Ref R/184/17/PD

Application for change of use of 51 Sea Lane from Class A1 shop to Class A3
Restaurant and Cafe

**APPENDIX ONE:
DRAWING SHOWING EXTERNAL EXTRACT AND VENTILATION EQUIPMENT PROPOSED**

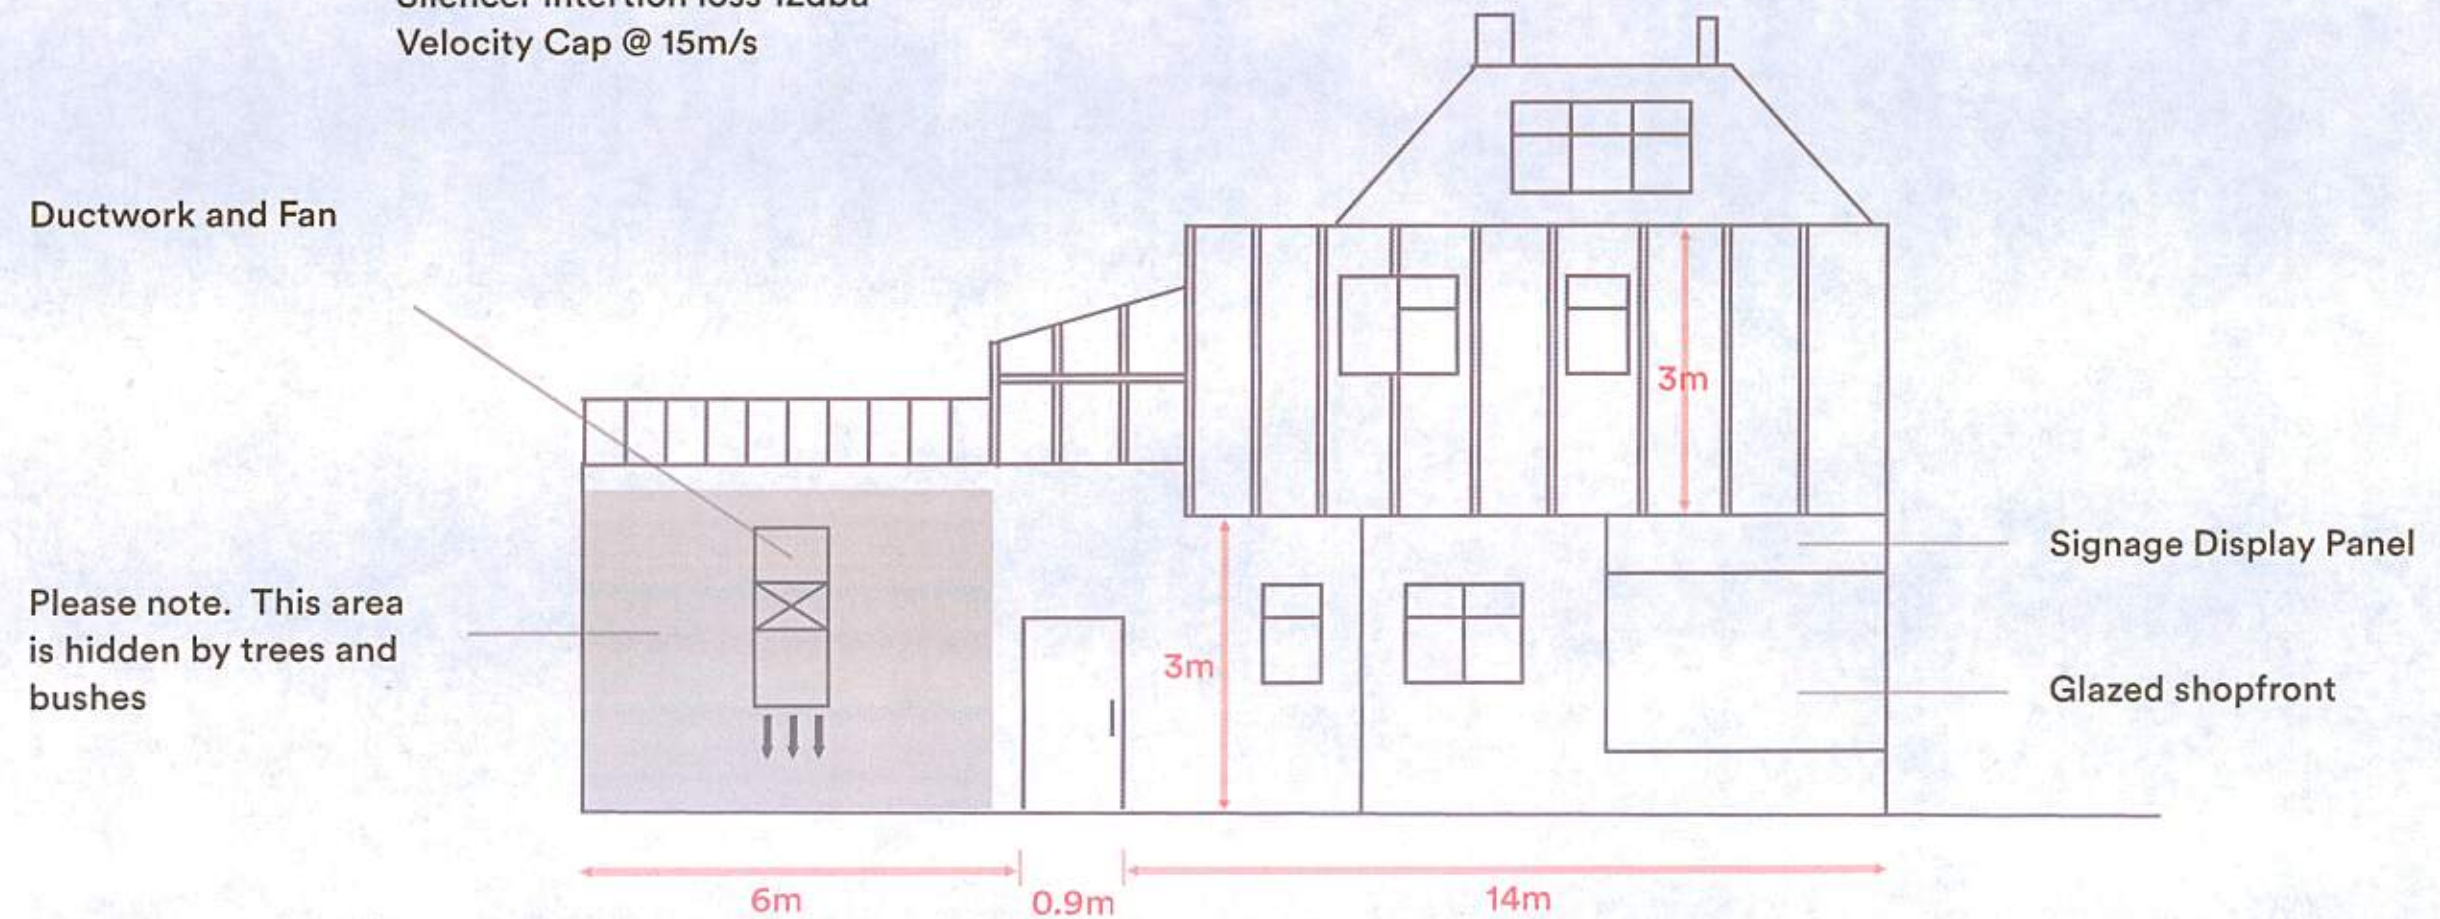
The positioning and use of a venting system for the proposed kitchens, which are
according to the plans to be hidden by trees. Surely this then proposes a fire risk,
particularly as the houses directly opposite the side entrance to number 51 is
thatched. Secondly such a venting system would produce noxious odours and
considerable noise.

APPENDIX TWO:
DRAWING SHOWING PROPOSED REFUSE FACILITIES

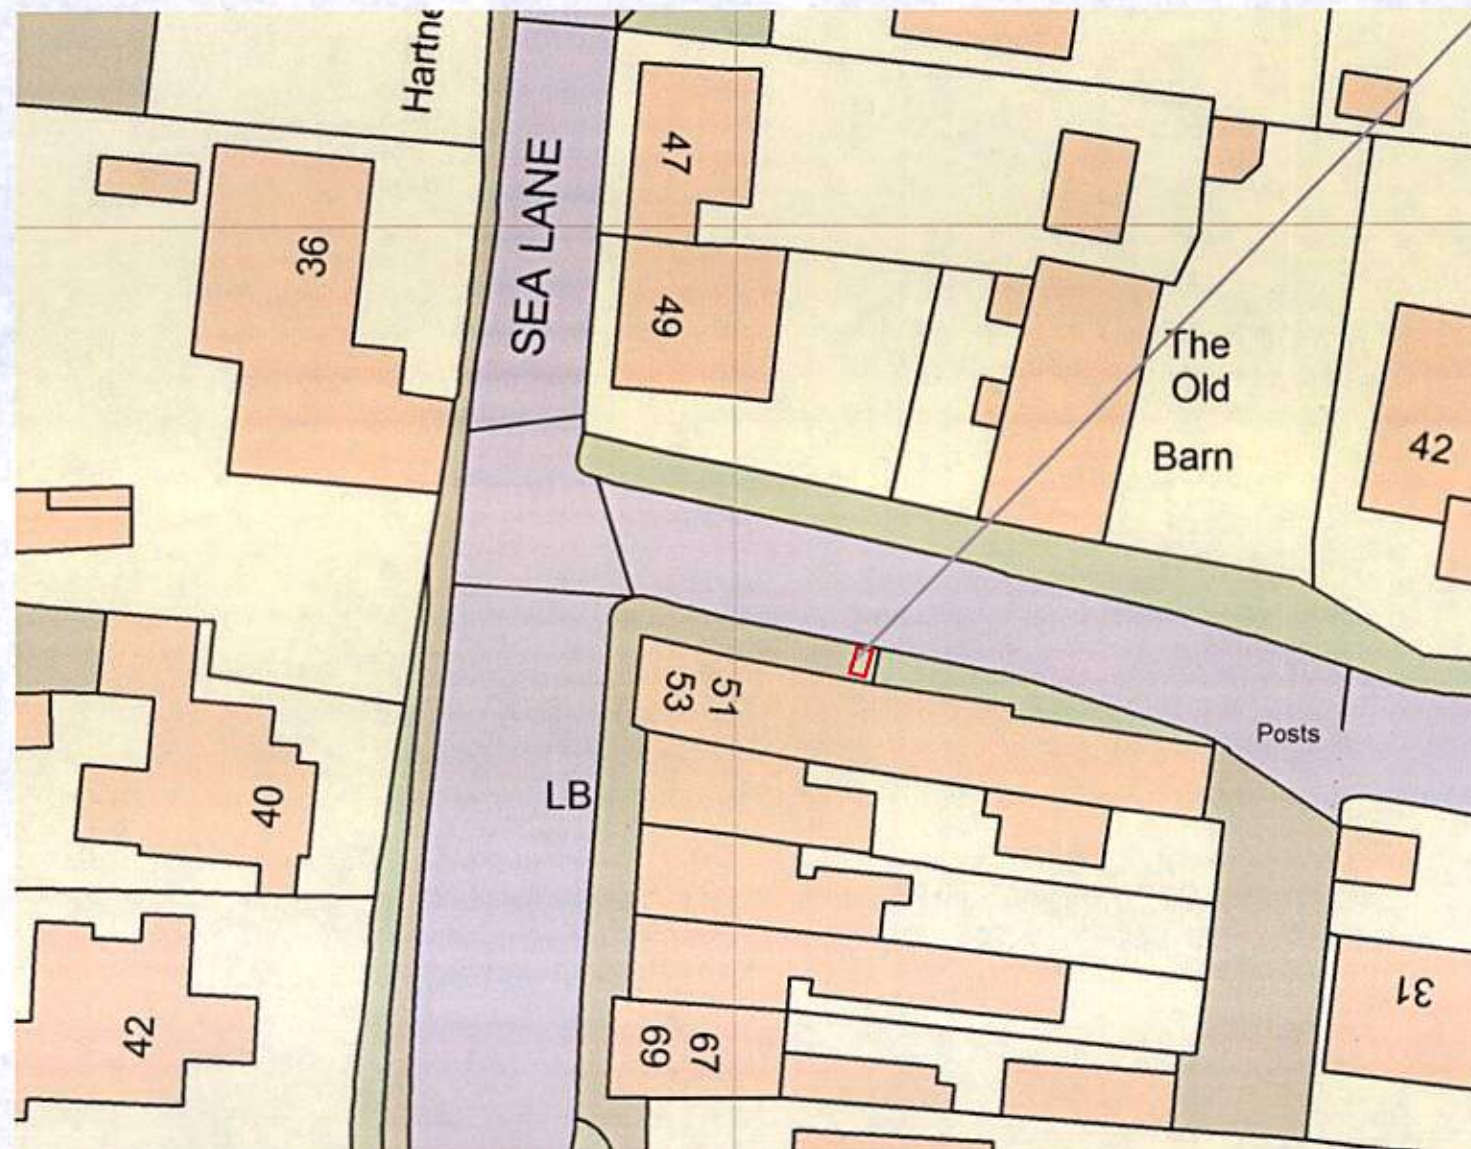
The potential for increased rubbish that will attract vermin and foxes with the
attendant health concerns.
